## **SSD 8175 – WESTERN SYDNEY STADIUM (STAGE 2) - EIS**

## ATTACHMENT A

#### WESTERN SYDNEY STADIUM STAGE 2 – CONSTRUCTION AND OPERATION

## APPENDIX ONE – SOUNDPLAN NOISE CONTOURS

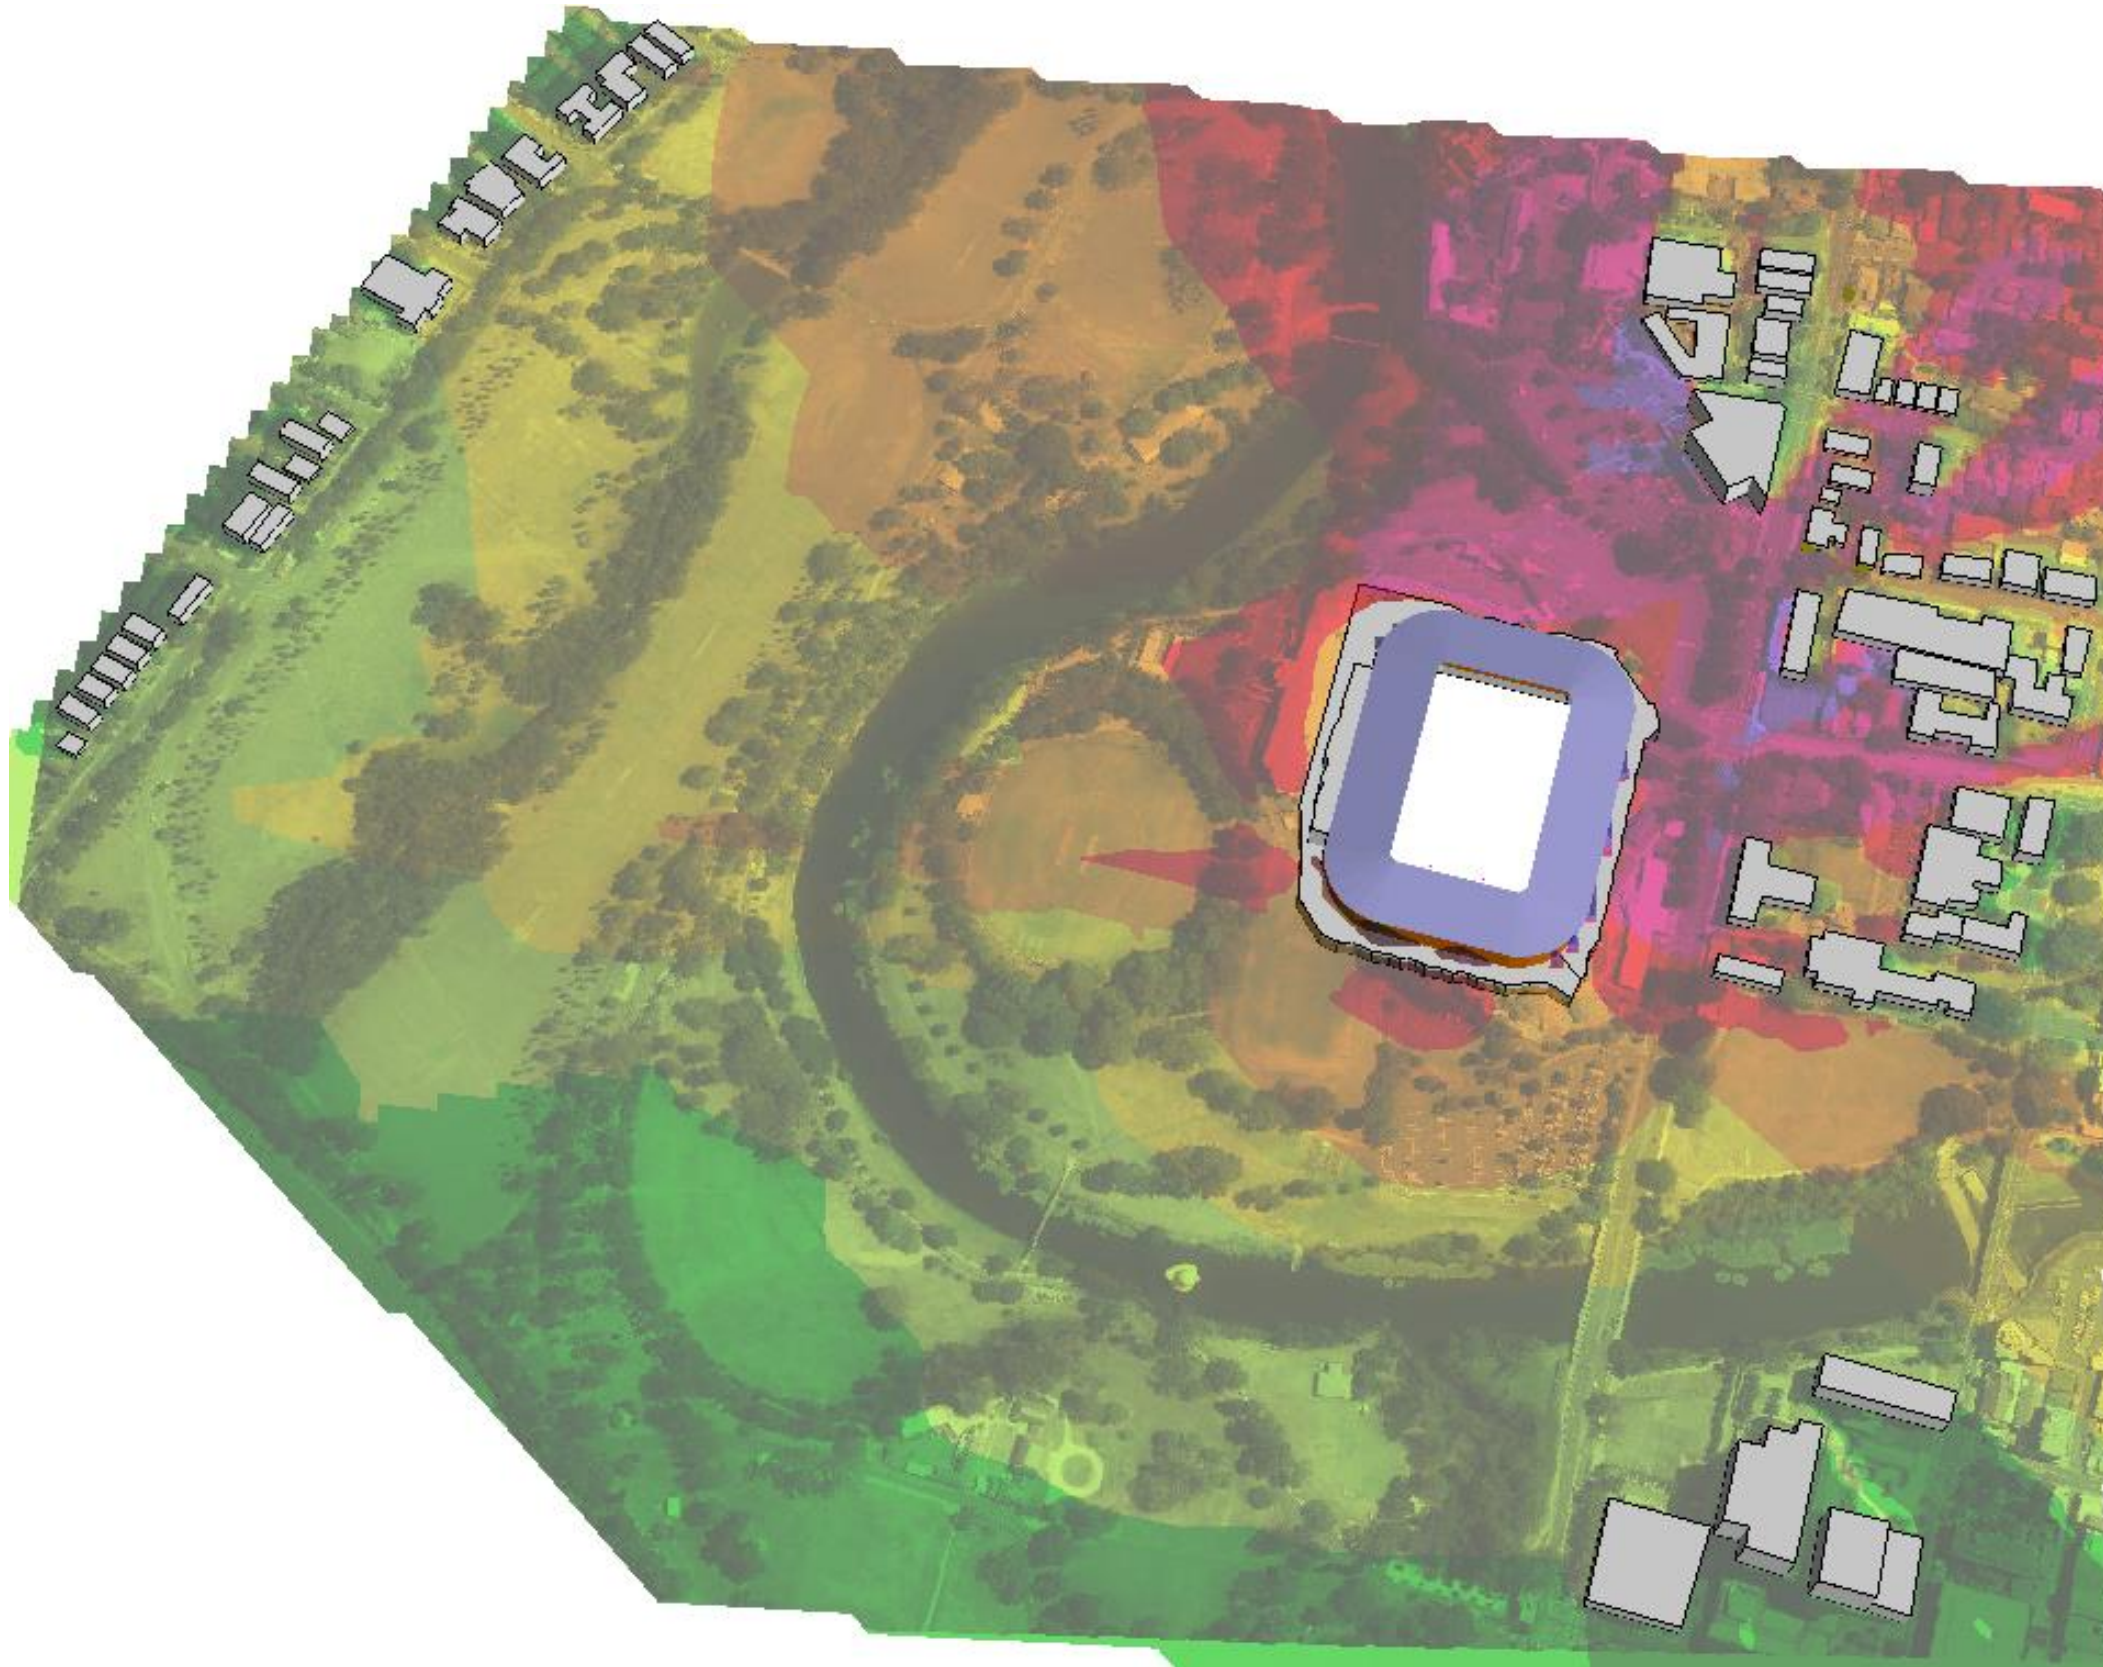
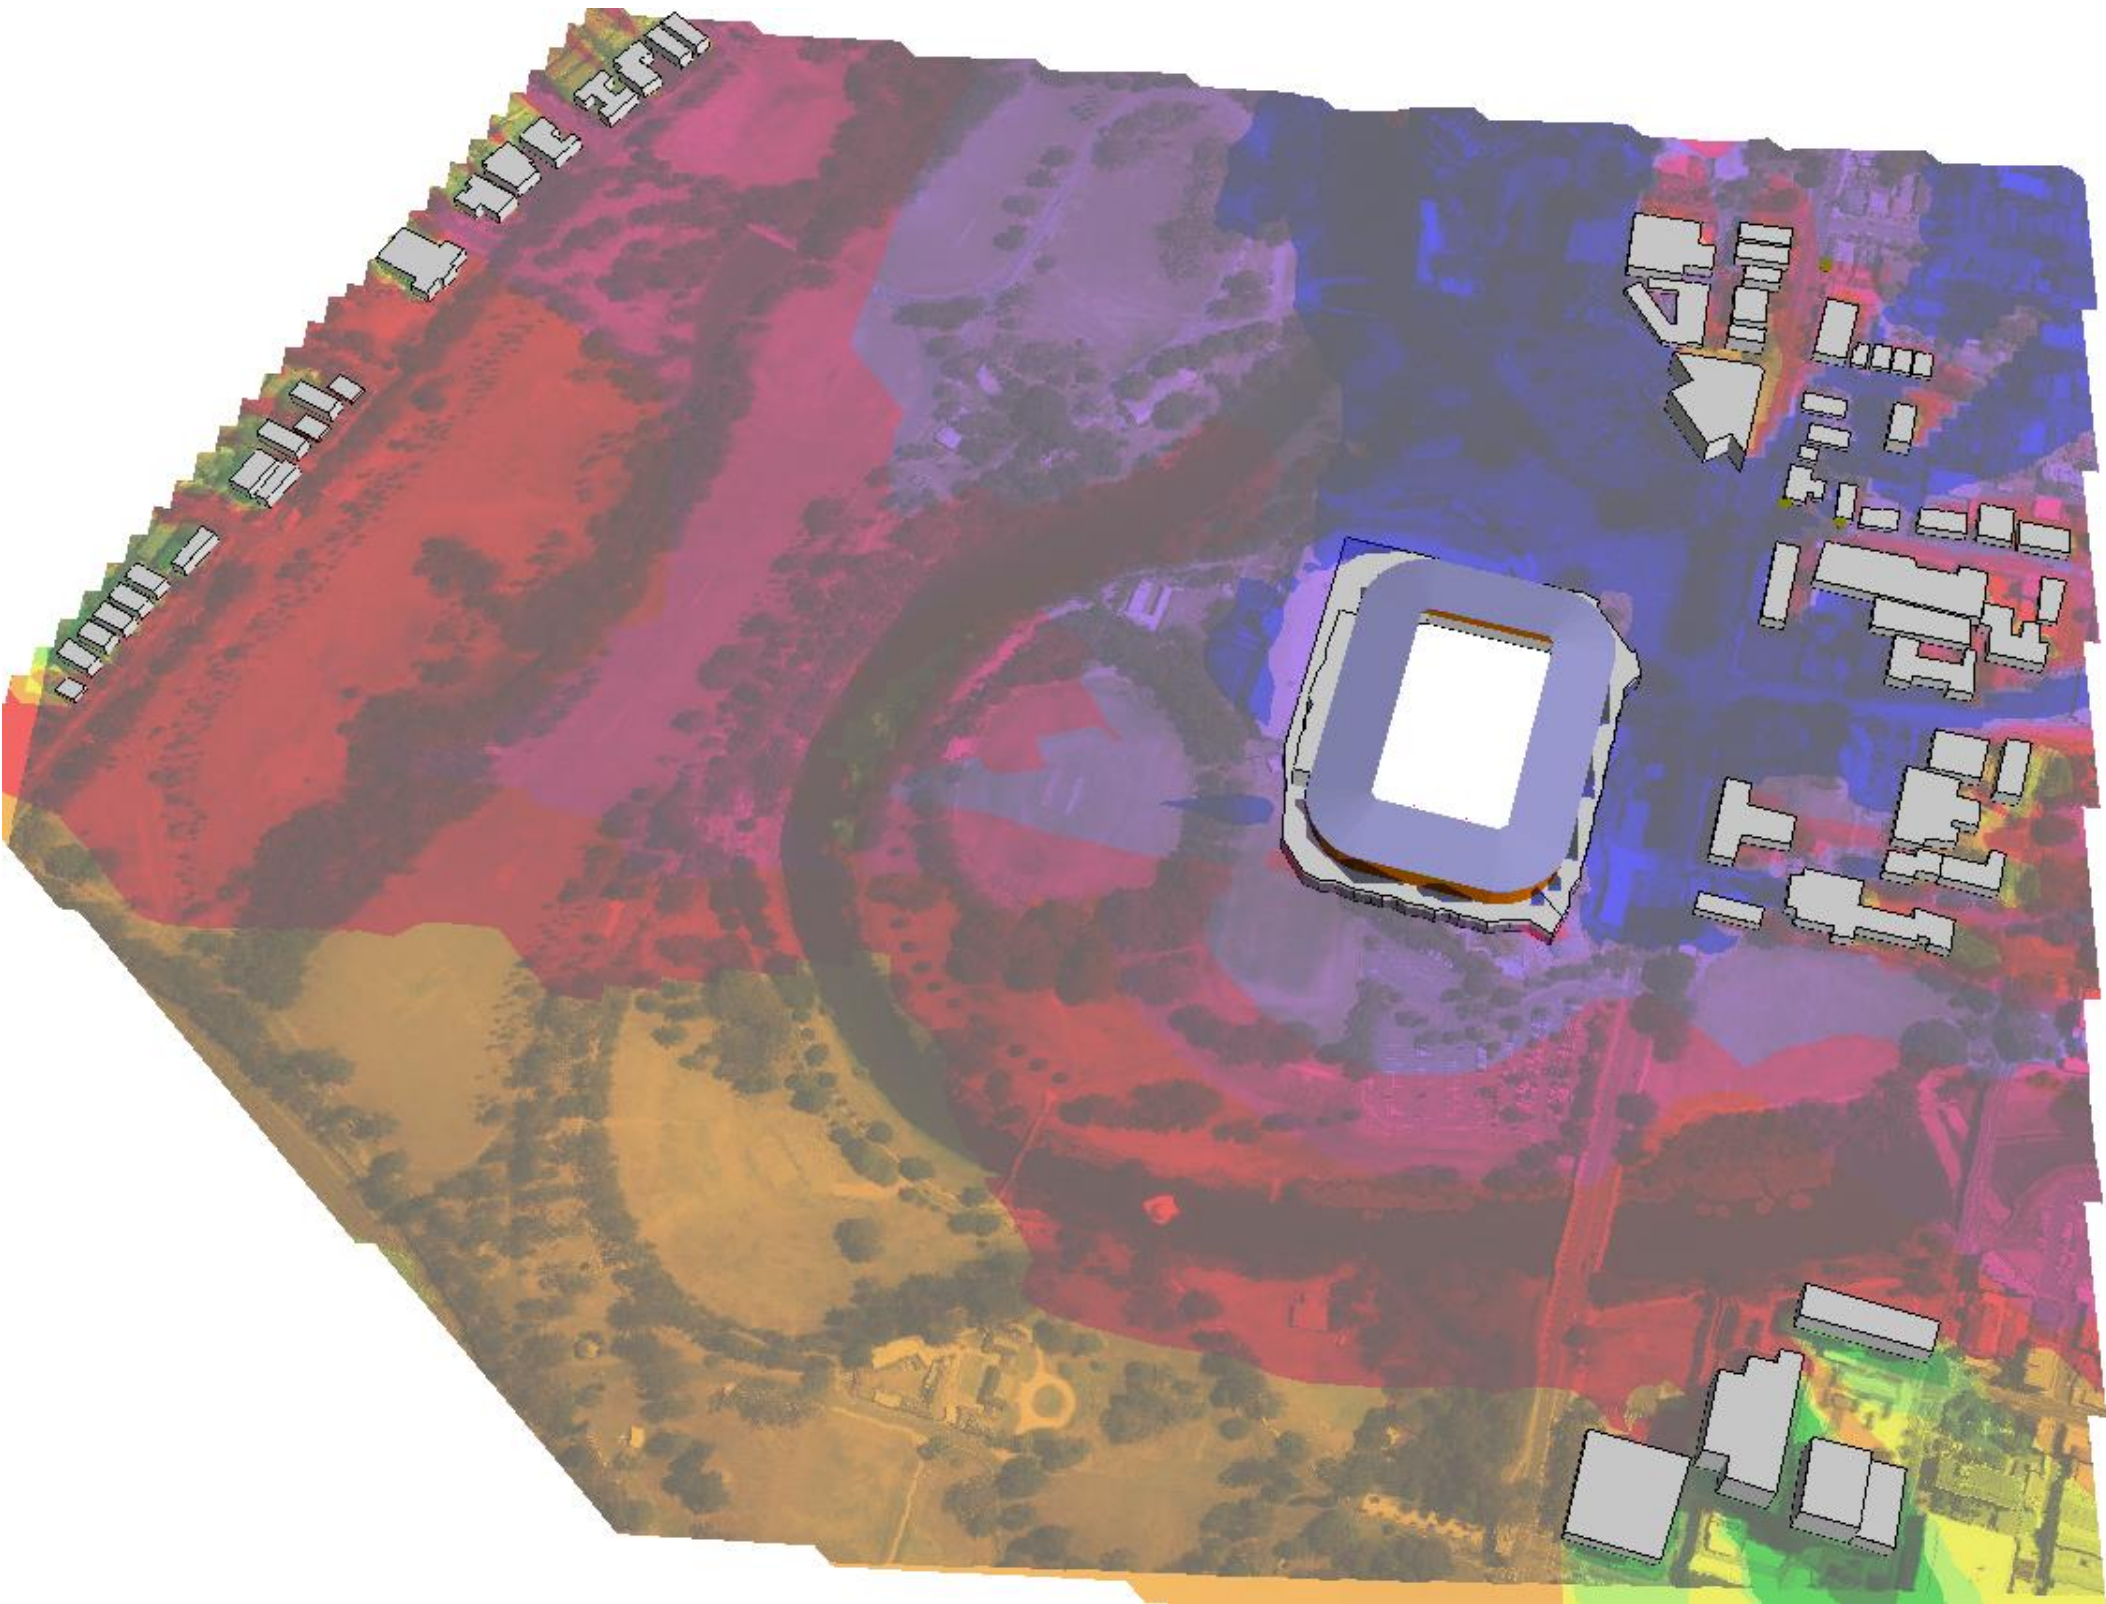
The EPA acknowledges that whilst predicted operational noise contours are presented (developed using proprietary noise modelling software), EIS Appendix S does not include –

- (a) tabulated data using the various recommended A and C weighted noise descriptors required to facilitate proper evaluation of those predicted noise impacts,
- (b) details of predicted day-time noise impacts on non-residential noise sensitive land uses.
